**Consultation Response from KC,
Lead Local Flood Authority**

2026/90804 Barncliffe Mills, Near Bank, Shelley, Huddersfield, HD8 8LU

Outline application for residential development with all matters reserved except access

Date Responded: 07/05/2026.

Drawing Number: **P4801-01** Rev: **P01**

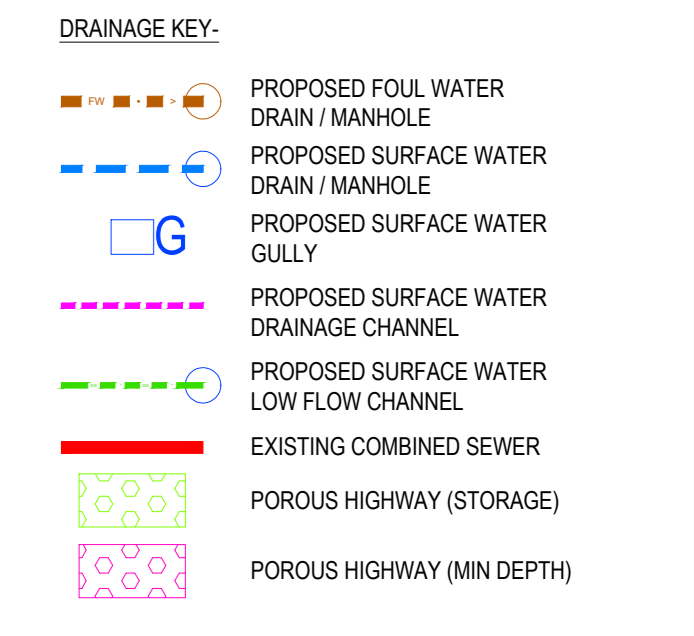
The LLFA confirms that the proposed **3.0l/s** allowable surface water discharge to the adjacent watercourse is acceptable.

Kirklees Council mapping indicates a watercourse (a tributary of Shepley Dyke) running from south to north adjacent to the western boundary of the site that appears to cross under the unadopted Hey Moor Lane at the northern end of the site via a culvert. The mapping also indicates surface water flooding across part of the site to a depth of up to 300mm.

The condition of the culvert will need to be determined by the developer and a CCTV Survey report submitted to the LLFA prior to construction activities. The culvert will need to be repaired/cleaned out if required. A debris screen (designed to CIRIA 786 requirements) will also need to be provided at the upstream end of the culvert to prevent litter, leaves, footballs, etc. from blocking the culvert. The screen and watercourse within the site boundary will remain private and the maintenance needs to be undertaken by a maintenance contractor and subject to a Section 106 agreement
